Re: Status of Repair Application: EH2103-0013

An attempt was made to evaluate your property for the purpose of issuing a Repair Permit. The evaluation could not be completed for one or more of the following reasons.

Harnett County Department of Public Health Site Sketch

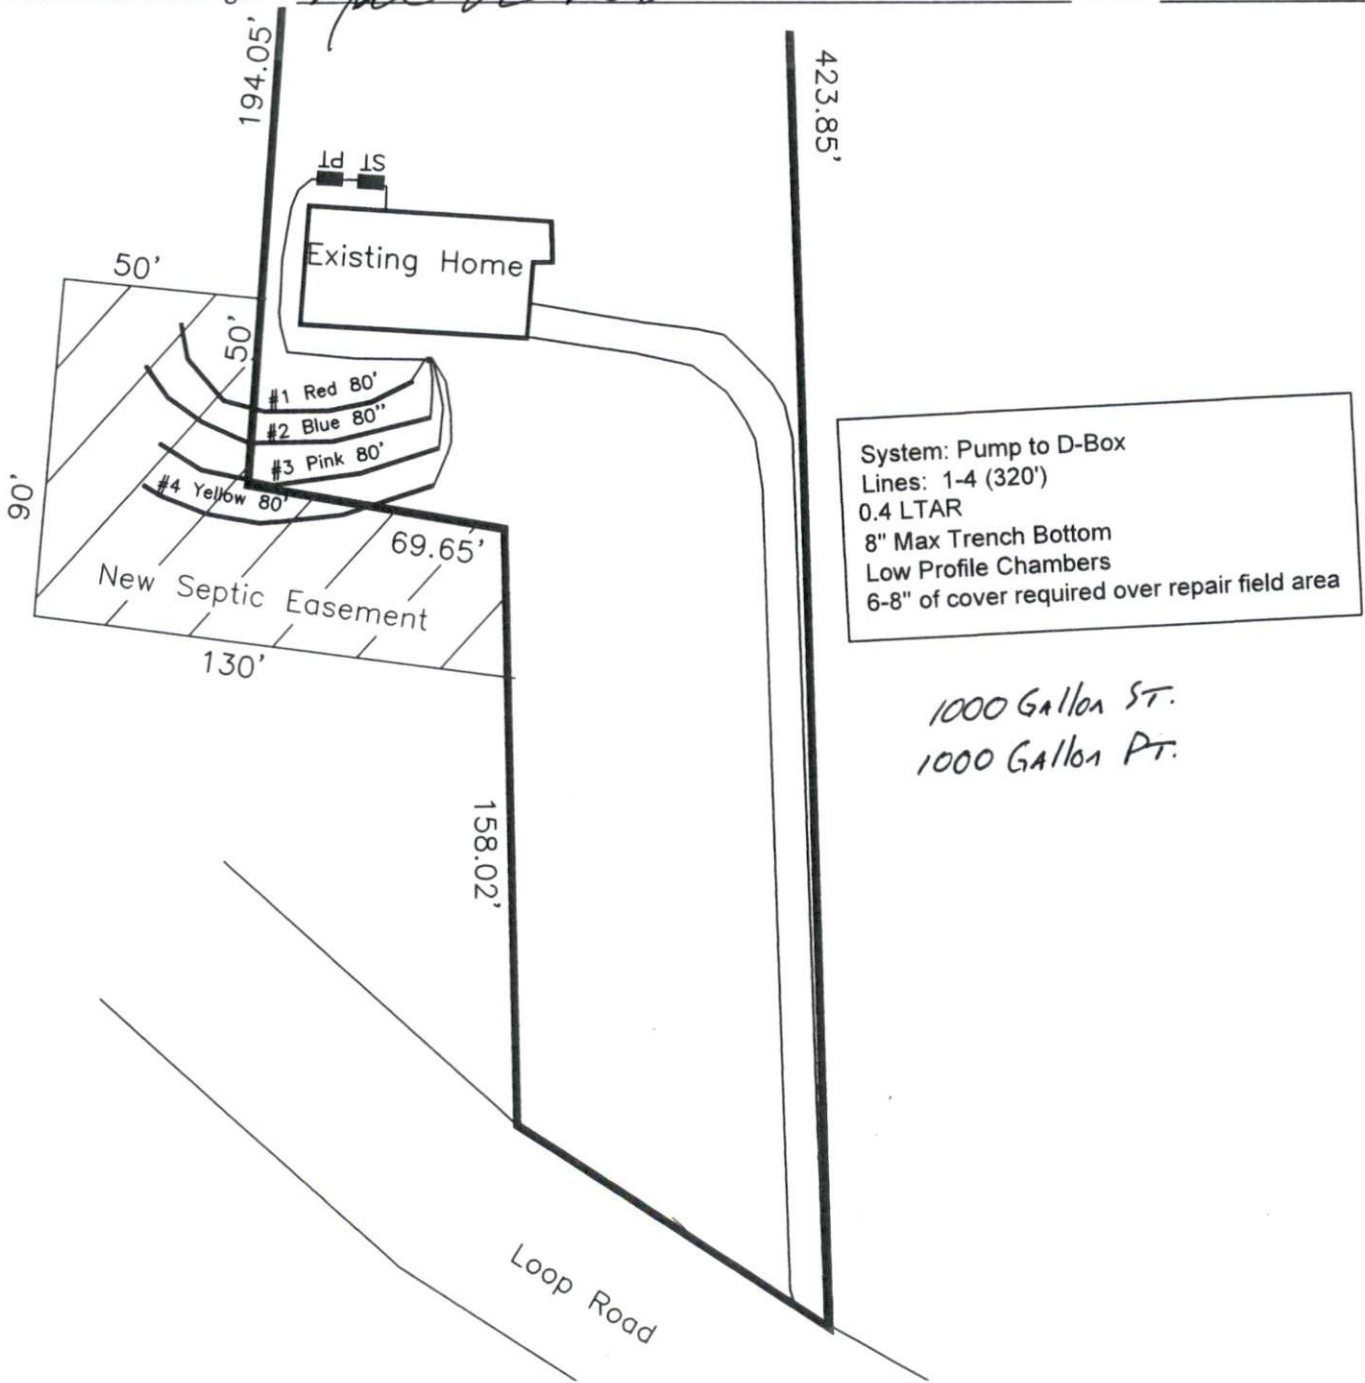
- 1. Use pink flags to mark property lines and **irons that are set by surveyor need to be visible.** (As soon as this is done I can release the permit)
- 2. Use orange flags to mark house box.
- 3. Directions not clear to property (\$25.00 fee incurred)
- 4. Property needs cleared
- 5. Driveway not shown on site plan (Revision Required)
- 6. Backhoe pits required
- 7. Other-
